BUILDING CODE OF AUSTRALIA ASSESSMENT
AUSTRALIA SYDNEY 1 PROJECT

1.3 Purpose of the Report

This report has been prepared, on behalf of Crone Partners, to establish compliance to the Building Code of Australia and relevant Acts and Regulations of the development application documentation for the proposed works.

drawing title
INDICATIVE DRAWING
BASEMENT 1

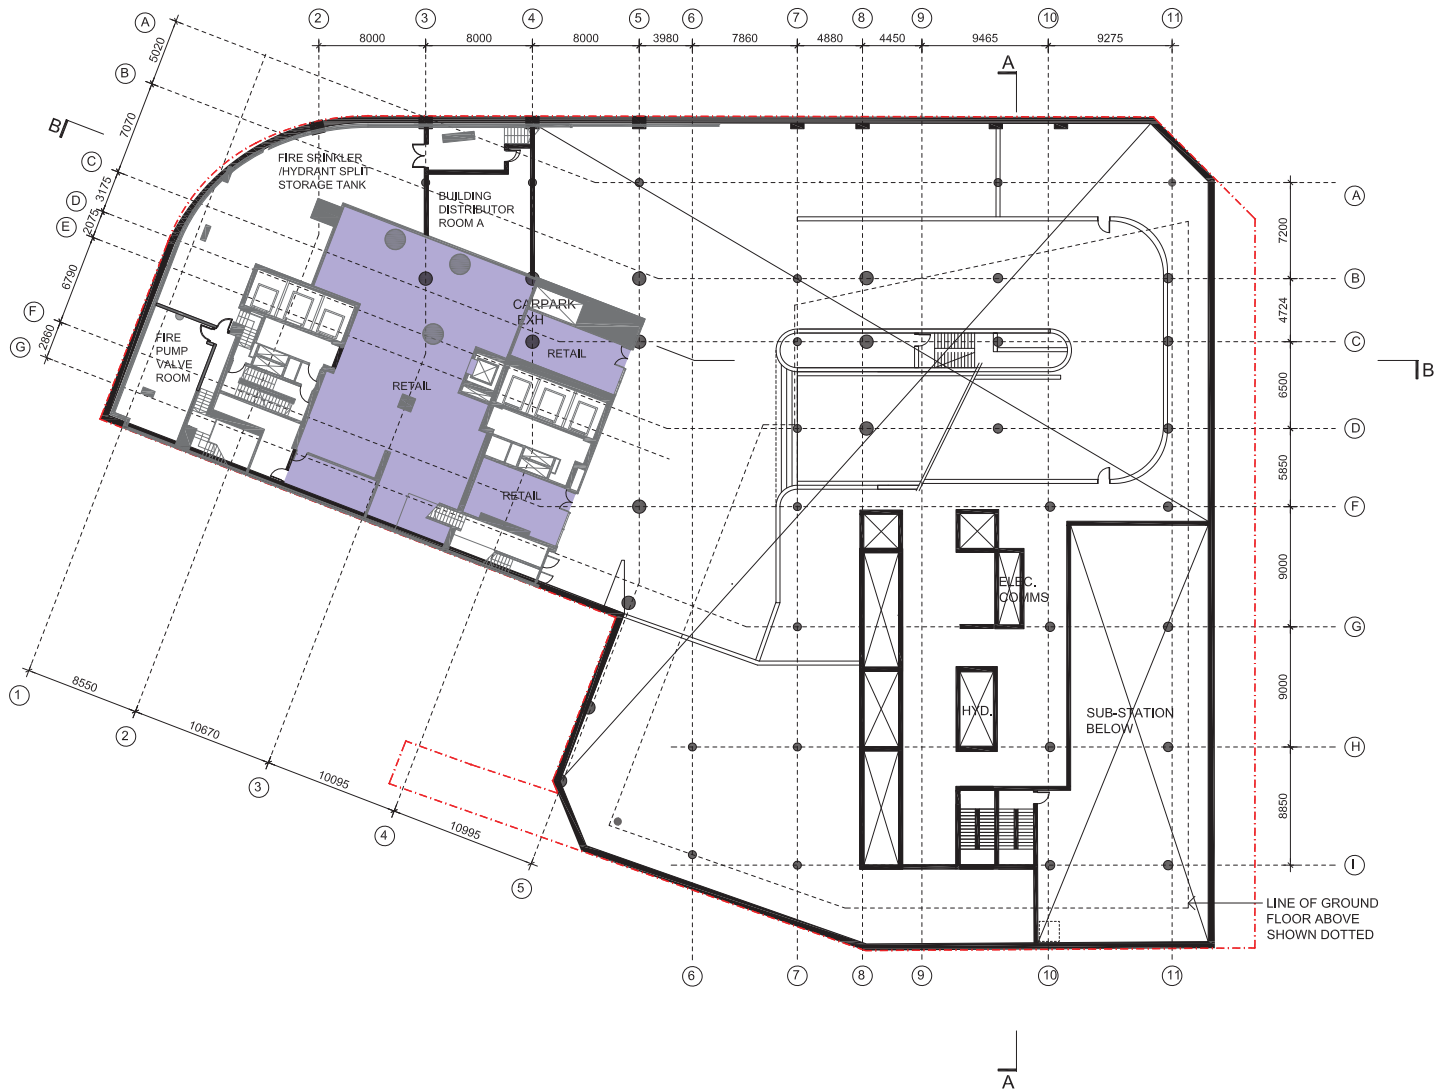
- 4.2.1 B6 to B1 – The final design is to achieve a maximum travel distances of 30m to a point of choice and be addressed under the alternative solution.

- 4.3.1 B6 - Plant - 50m
 - 4.3.2 B1 – Grease arrestor (52m).
 - 4.3.3 B2, B3 & B4 – Bicycle store – 50m.
 - 4.3.4 B3 – Hotel Back of house – The egress will exceed 40m once the fitout is incorporated into the design.

- 4.5.1 B2, B3 & B4 – 65m between alternative exits (relying on 30 to POC).
 - 4.5.2 B3 – Hotel Back of house – The egress will exceed 60m once the fitout is incorporated into the design.

drawing title
 INDICATIVE DRAWING
 HOTEL GROUND - LOBBY

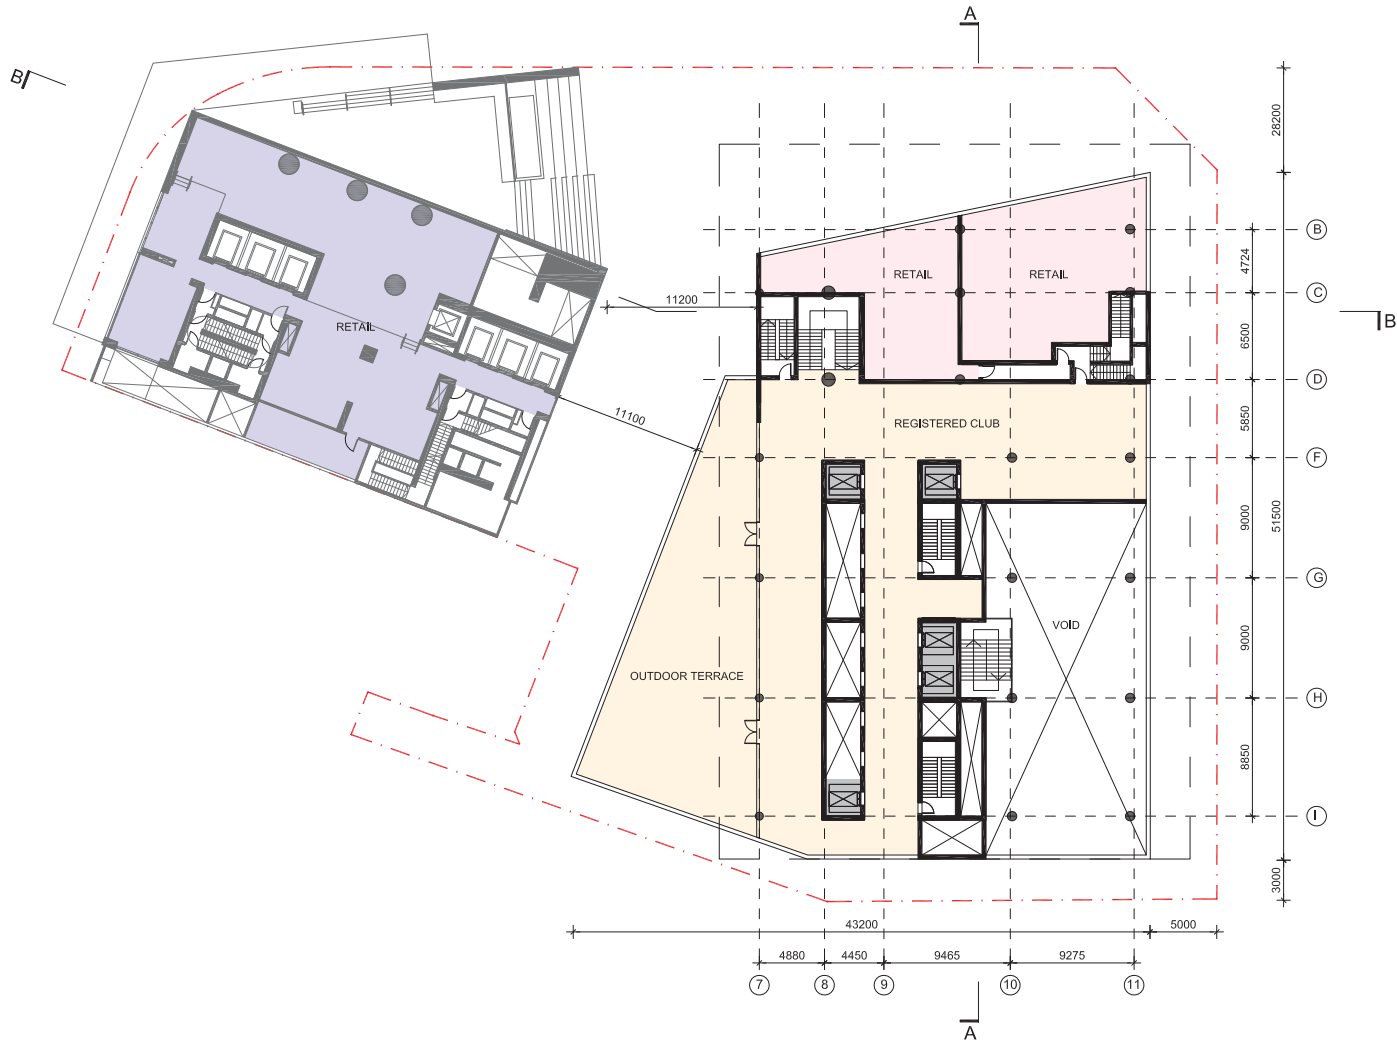
- 4.1.1 The retail tenancies on the ground floor with only the single doorway leading to outside.
- 4.2 Each area of the building (excluding residential) is required have access to alternative exits within 20m as per D1.4(c) of the BCA. The following areas exceed the limits permitted in the BCA and will require fire engineered performance justification;

- 4.14 The doorway serving as a required exit is required to swing in the direction of egress in accordance with D2.20. A number of doorways on the ground floor and basement swing in the opposite direction and require design modifications.
